Shannon Hernandez Macintyre
7520 Mercer Terrace Dr, Mercer Island WA, 98040

Date: April 19, 2024

Mercer Island Permit Number: 2402-026

We are the structural engineers of record for this project. This letter lists the comments related to the structural design and what was done to address each comment.

ADDITION SECTION & DETAILS

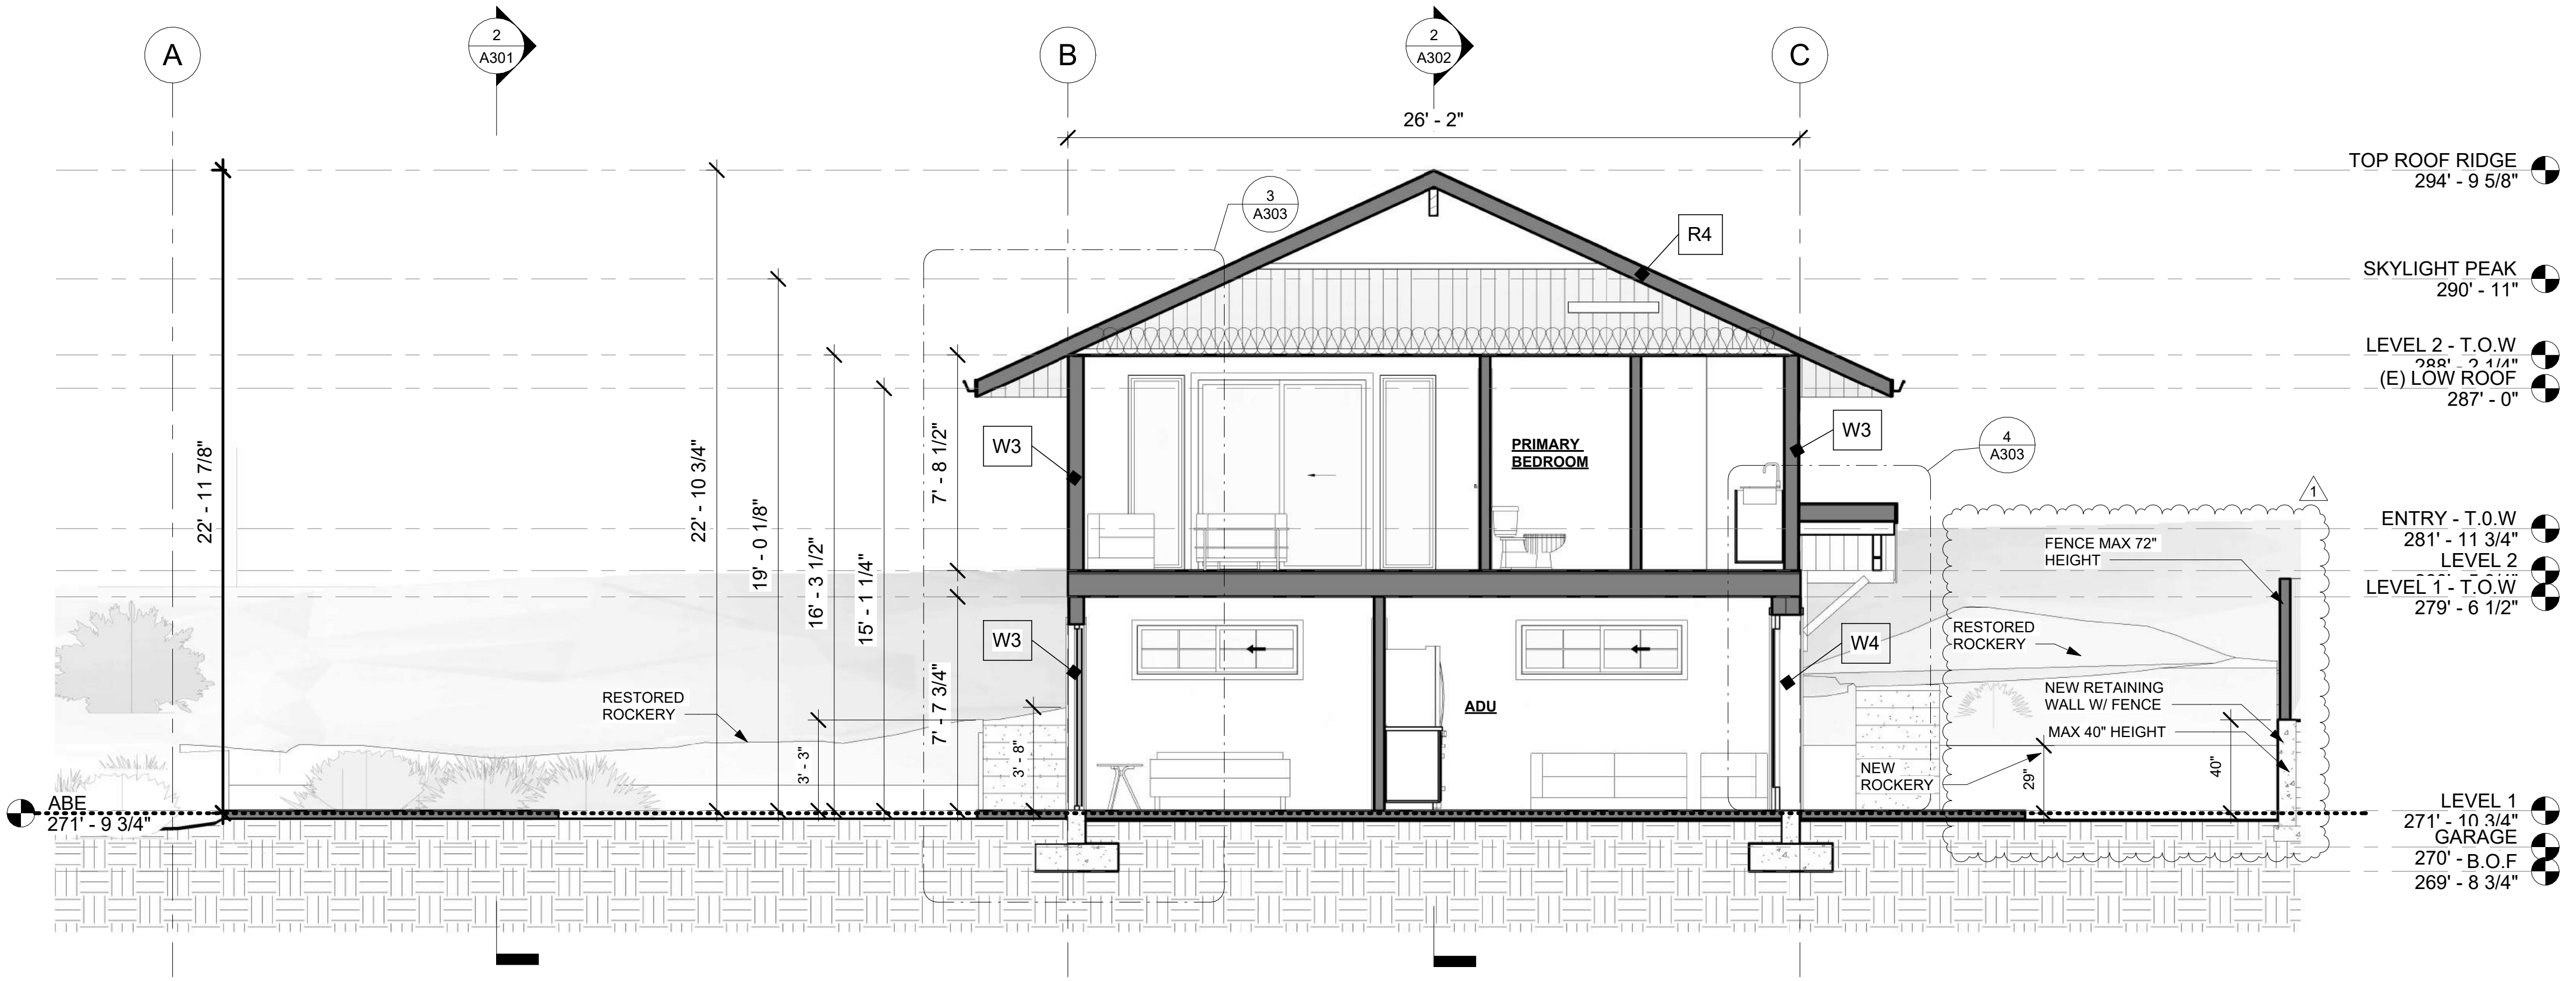
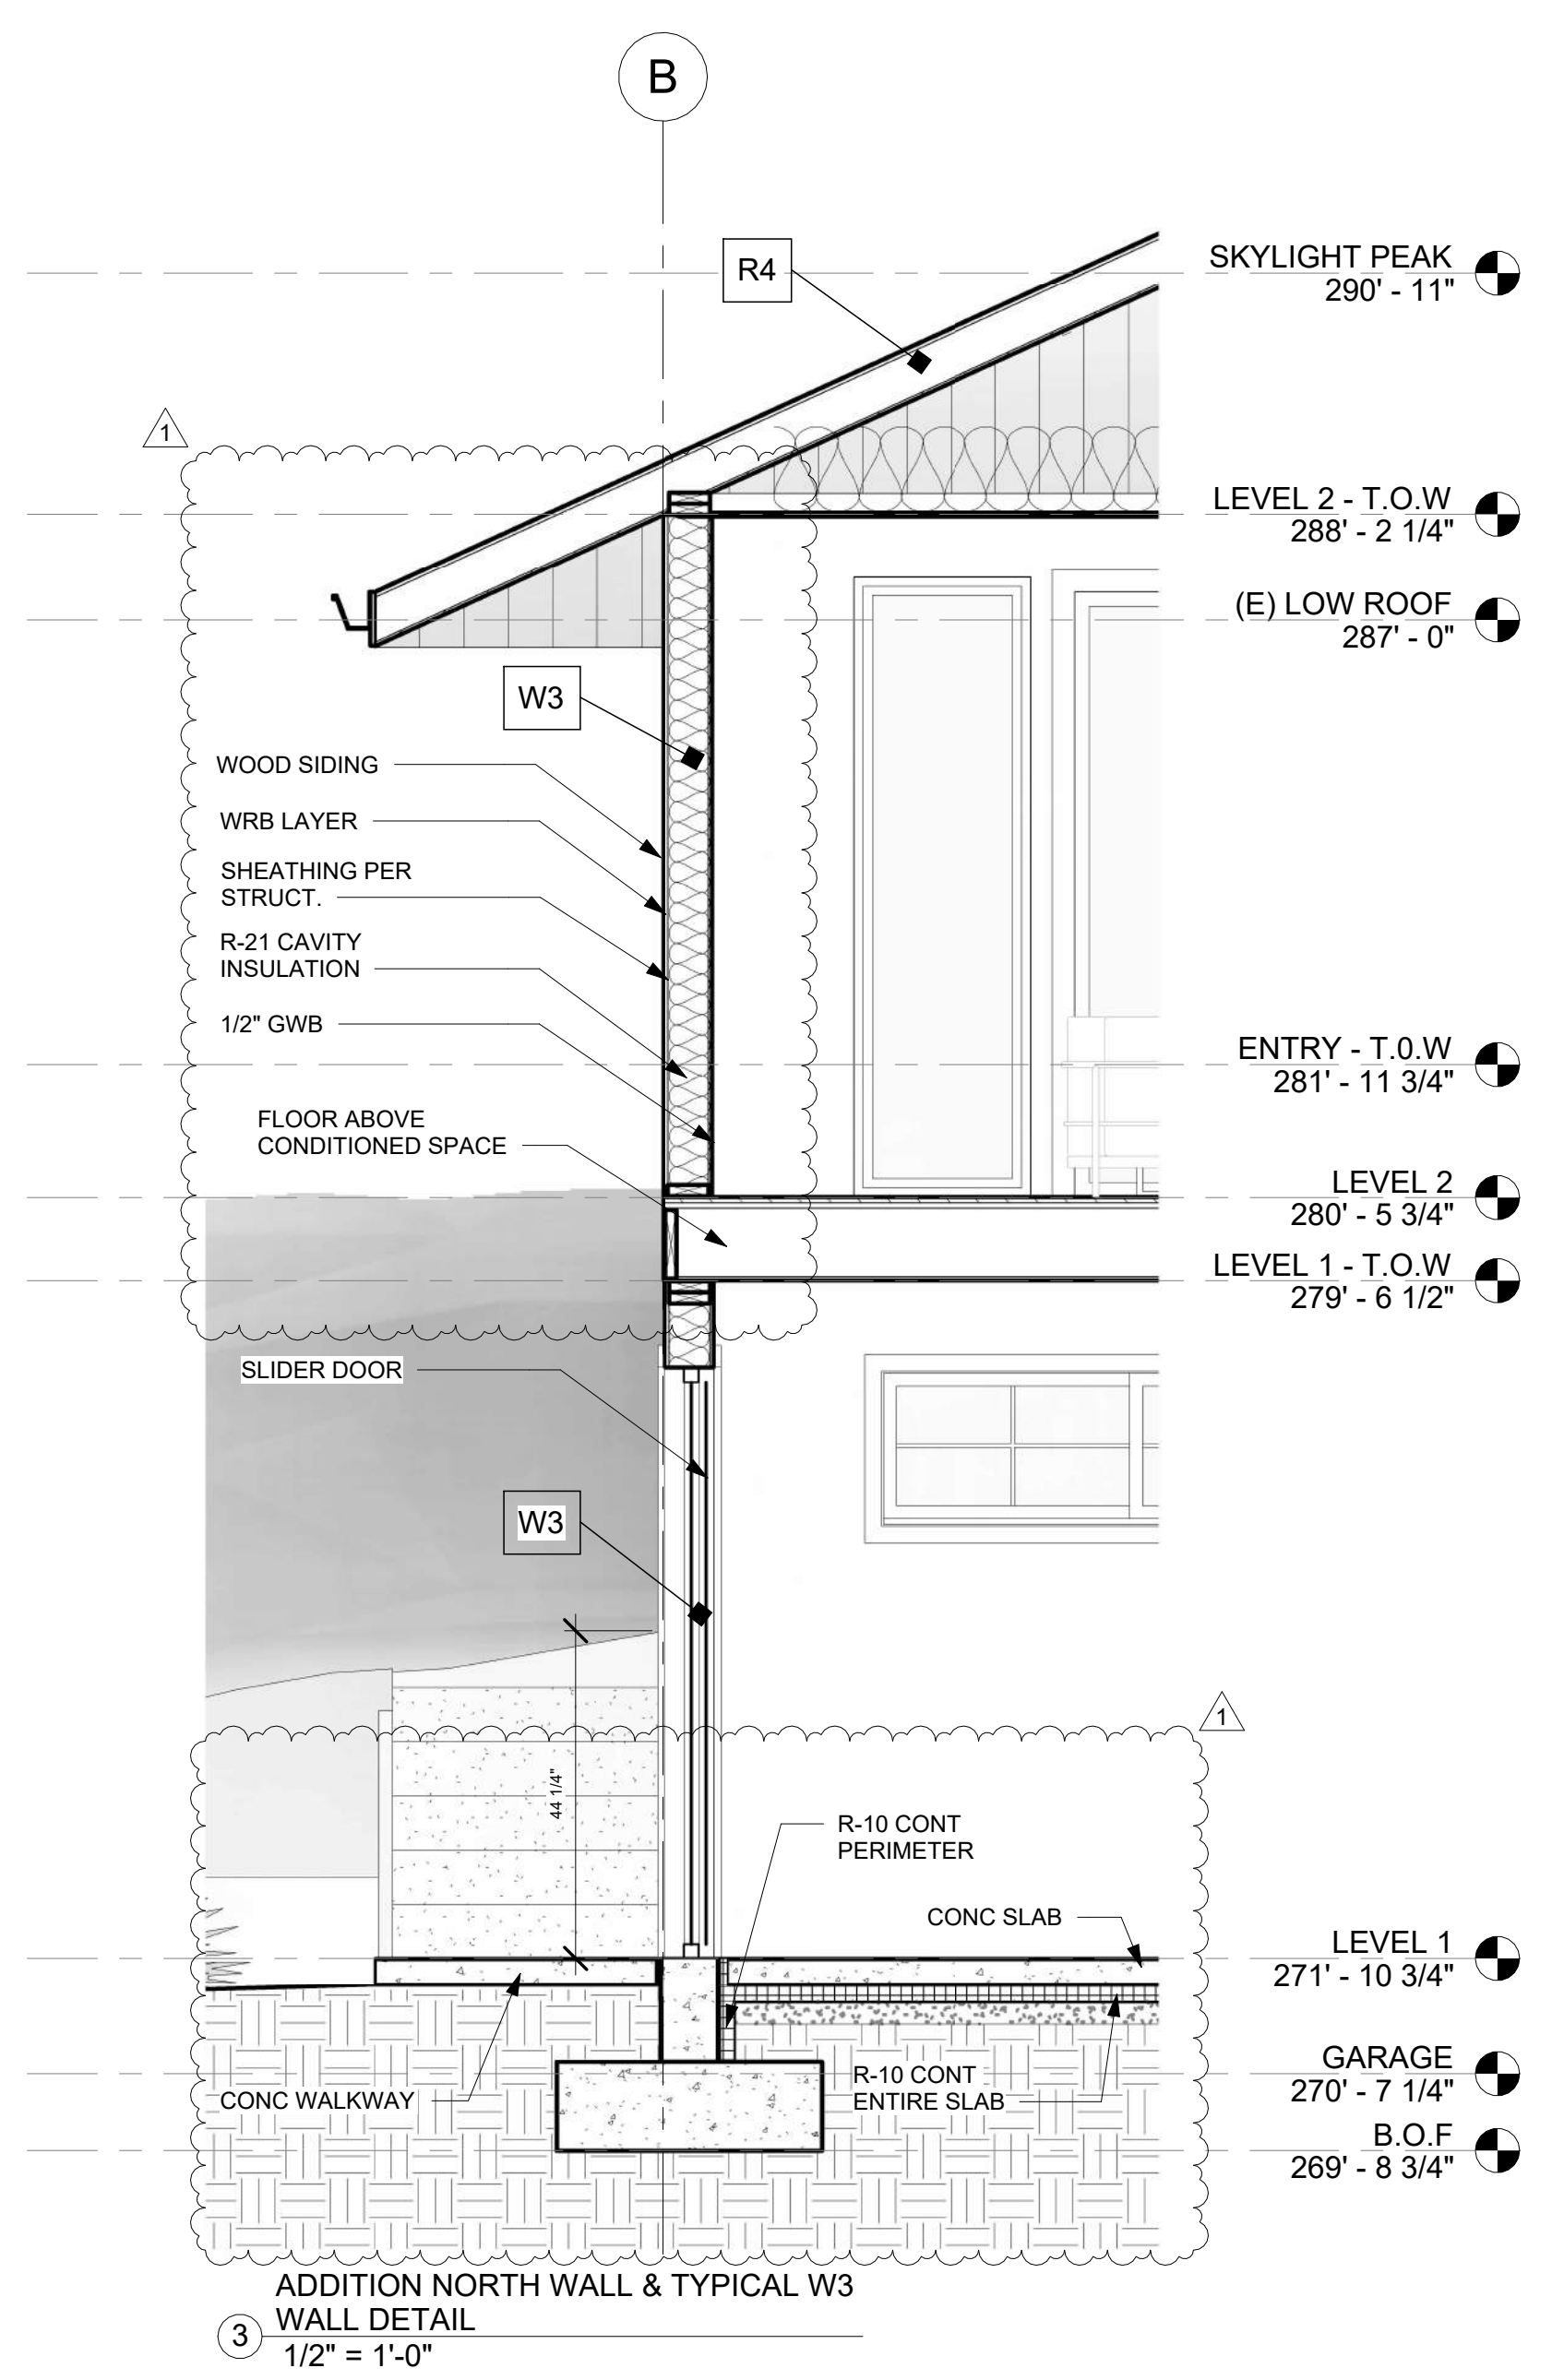
F2? Please provide detail or correct

Detail F3 shows an exterior footing with slab, this is the correct condition for this foundation according to sheet A303 of the architectural plans.
